From: [NectonSubstationAction Messenger](#)
To: [Norfolk Vanguard](#)
Subject: Comments to Secretary of State Letter
Date: 07 December 2019 09:00:28

From: [NectonSubstationAction Messenger](#)
To: [Norfolk Vanguard](#)
Subject: Additional Representation - information just come to light.
Date: 23 January 2020 16:56:24

From: [NectonSubstationAction Messenger](#)
To: [Norfolk Vanguard](#)
Subject: Additional Representation Just Come to Light
Date: 23 January 2020 16:53:43

Drawing file: EN010079 / EN010079-001897-Figure 29.09 Indicative Onshore Project Substation Mitigation Planting.pdf

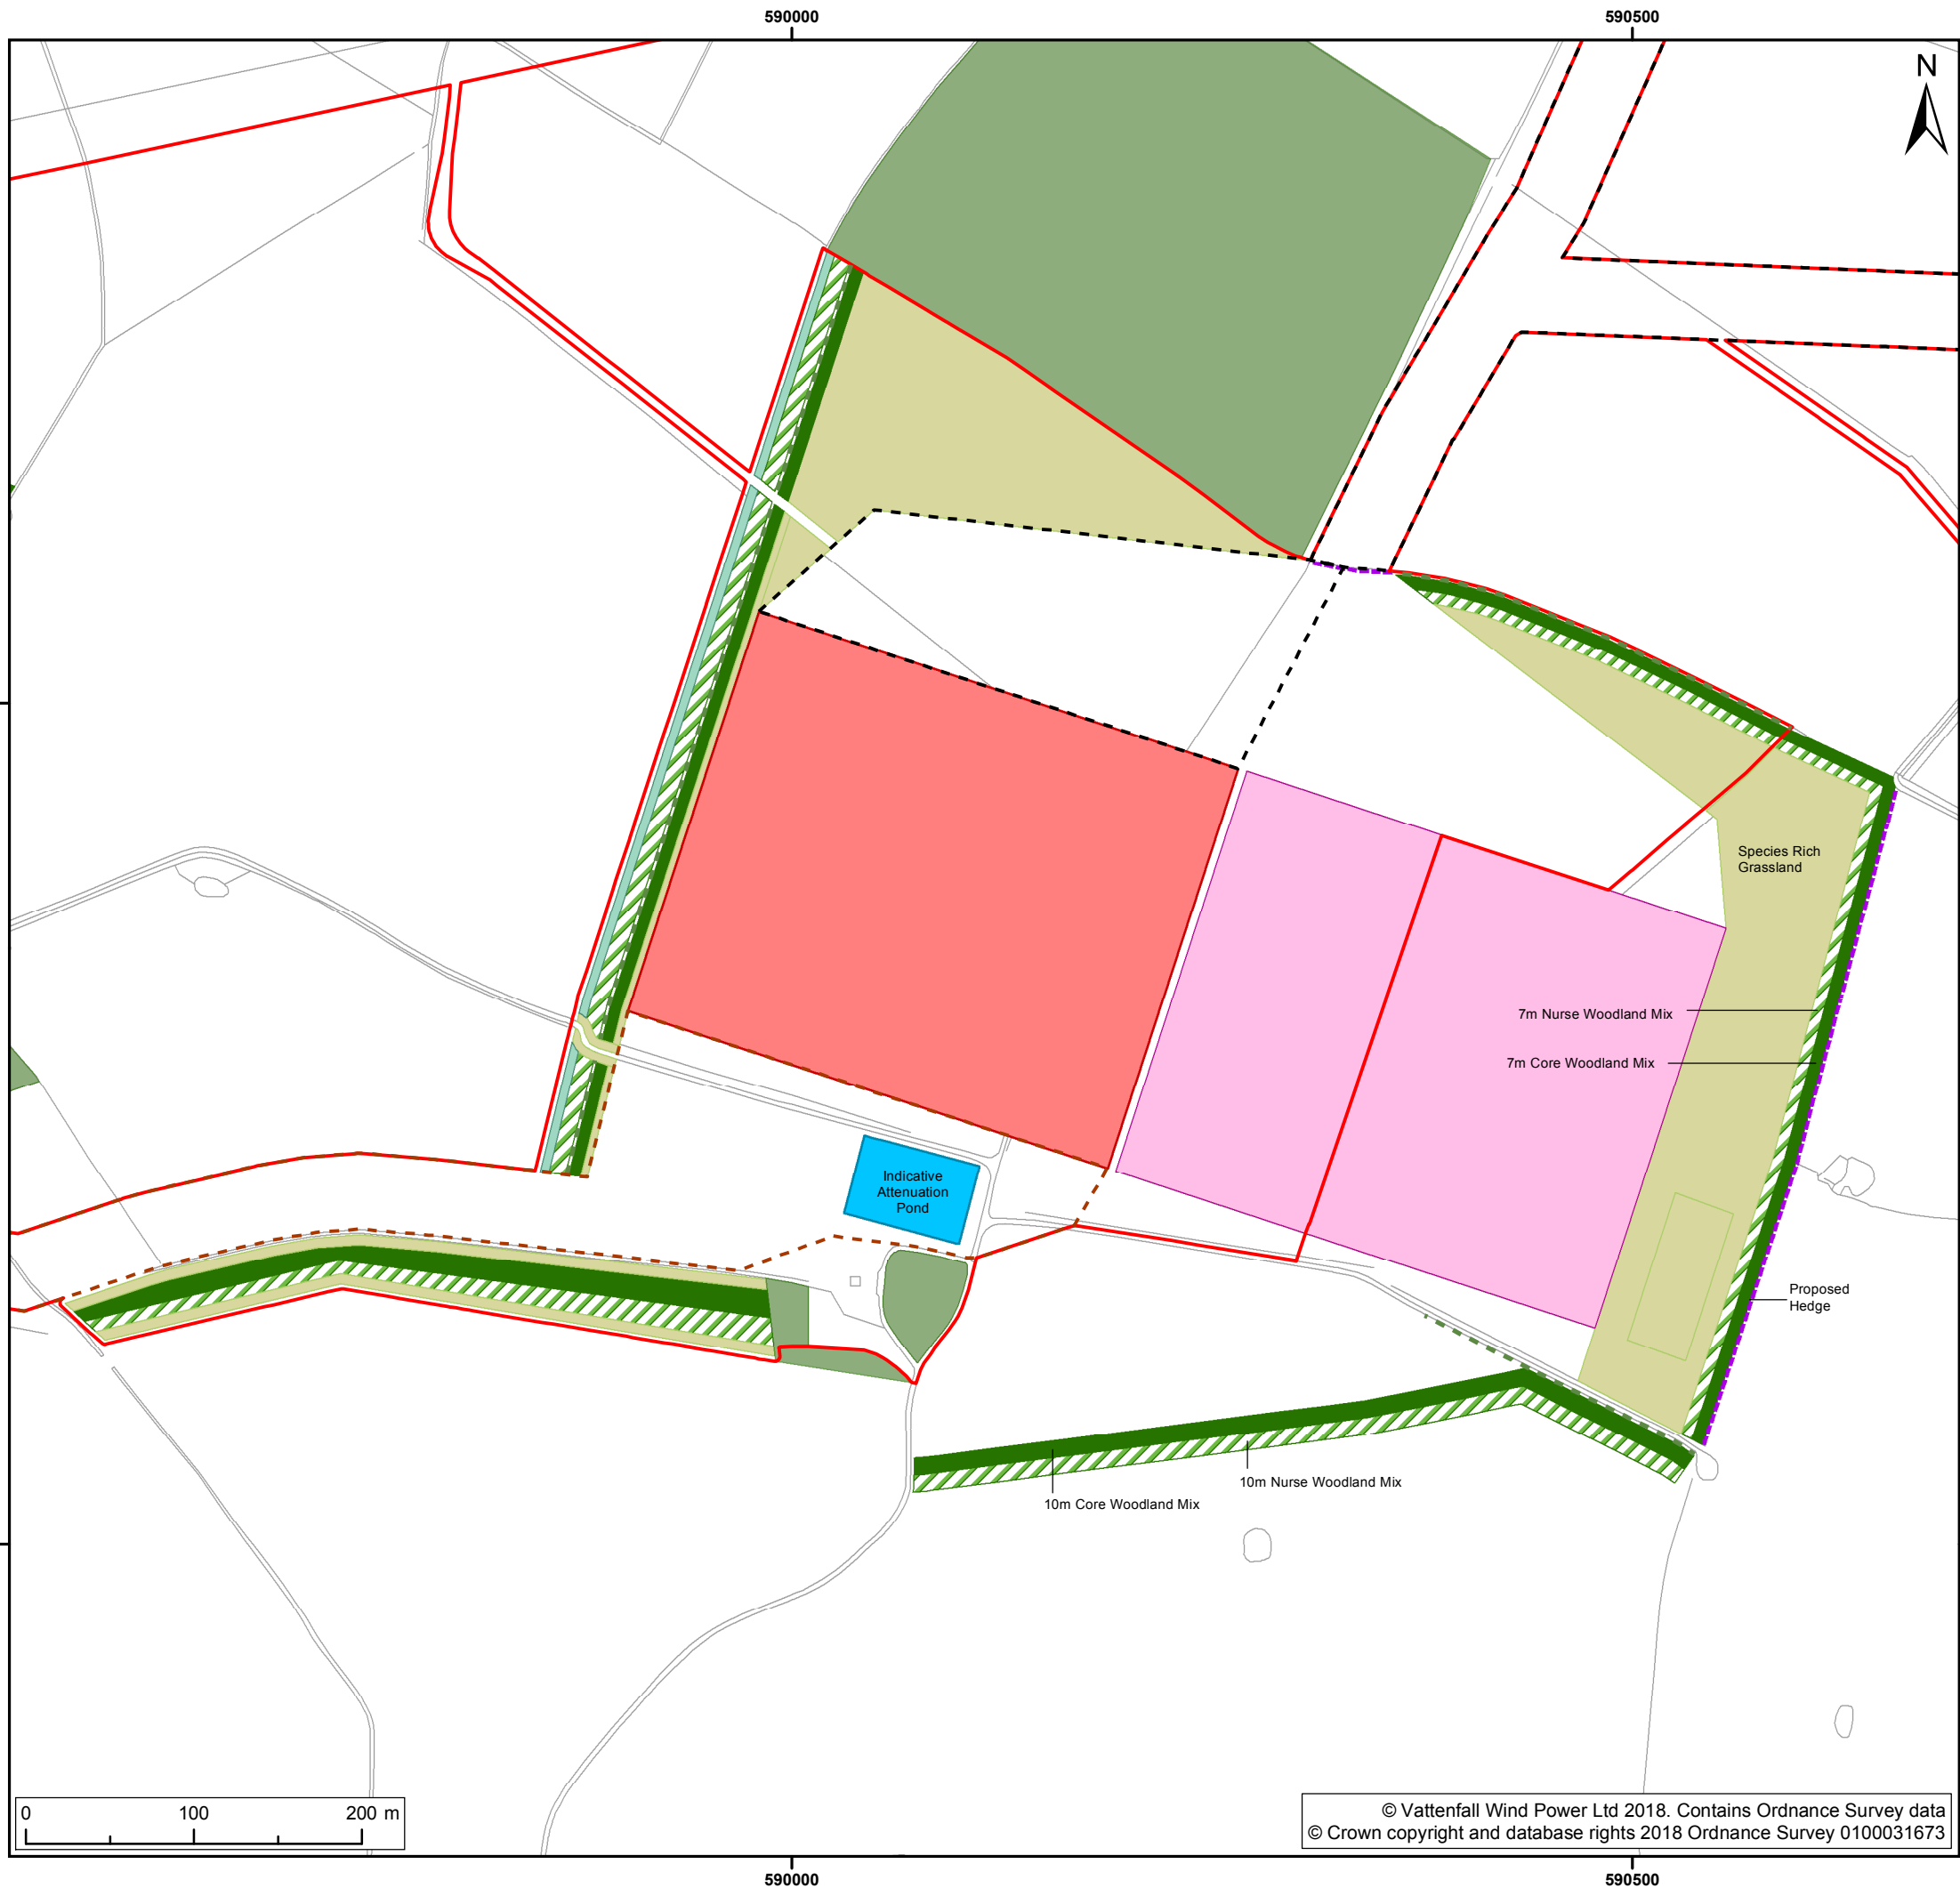
At the time we were told that the software did not recognise trees and hedges, so they were omitted, when in fact the truth appears to be that it was showing them as changes in land height and as ridgelines. It is on these non-existent ridgelines that the applicant plans to plant trees, when in fact they could well be 'invisible' or non-recognised hedges, not ridges, which of course they cannot plant on top of.

This endorses our great fears, that if the applicant's mitigation plans are taken at face value and the project is accepted, once the buildings appear, and the trees and hedges are planted, and the flaws become obvious, it will be too late for Necton and Ivy Todd, as we assume the applicant will not be told to remove the installation, or lower it at this point! Who will be complain to once the construction starts and things become clear.

Title:	Viewpoint 2: Lodge Lane South
--------	----------------------------------

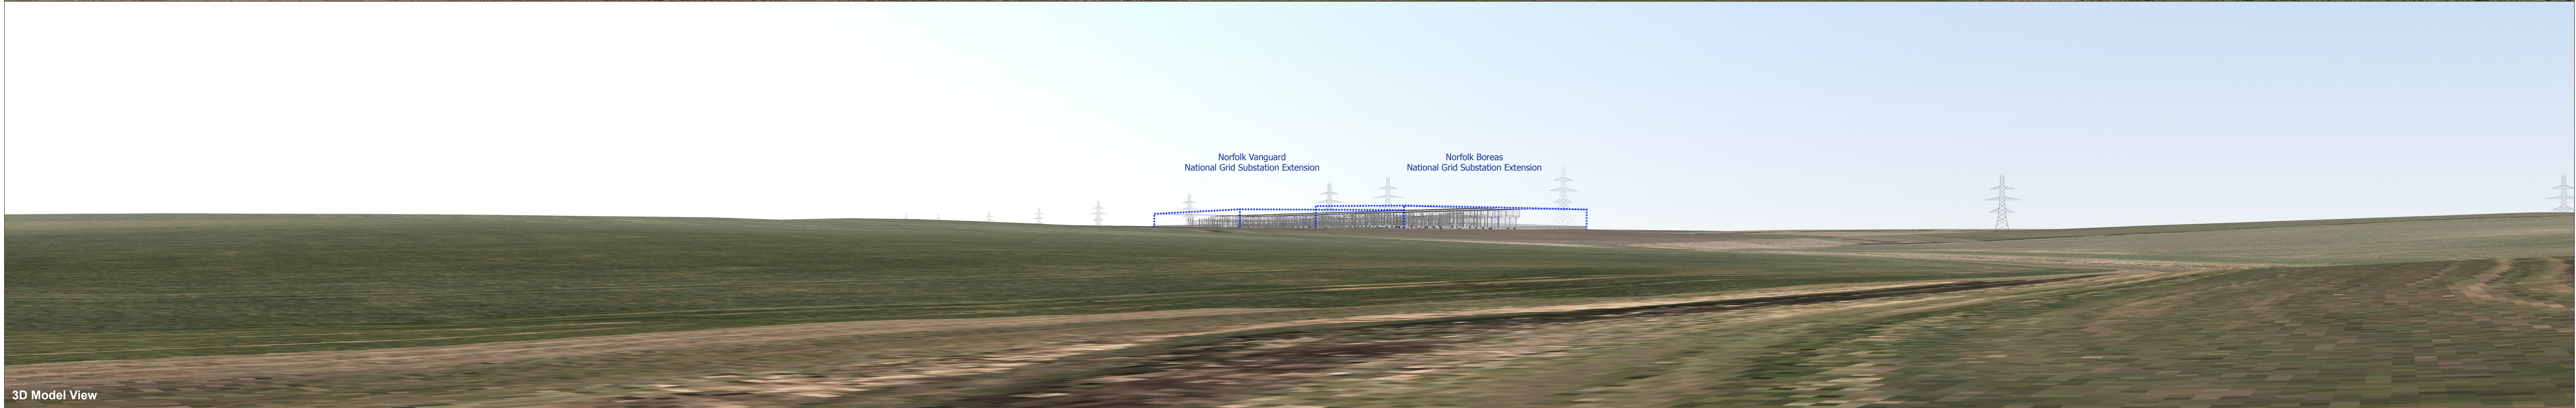
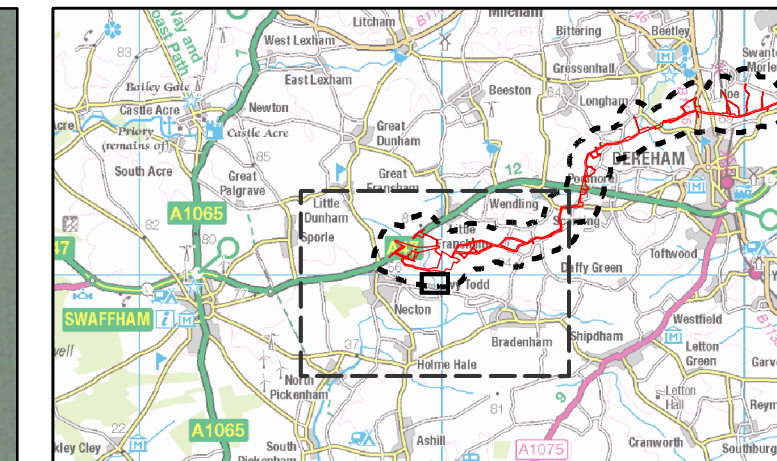
Mr Colin King's research (which will also be sent to you) has shown to our satisfaction that "the OS 5m DTM software used has an accuracy of +/- 2.5m rural, and less accurate where trees and buildings cover the terrain. The aforementioned mature woodland associated with Lodge Farm, has the capacity to cause a ridgeline great enough to cause the effect we are seeing at viewpoints 2 and 3 Lodge Lane."

Which means that the software is not only giving wrong heights for actual land, but also reading hedges, not as hedges but as land ridges. This would explain the fact that when they showed people the views from their own properties using their postcodes, no hedges appeared on the screen between the properties and the substations, and the ground was featureless as regards hedgerows.
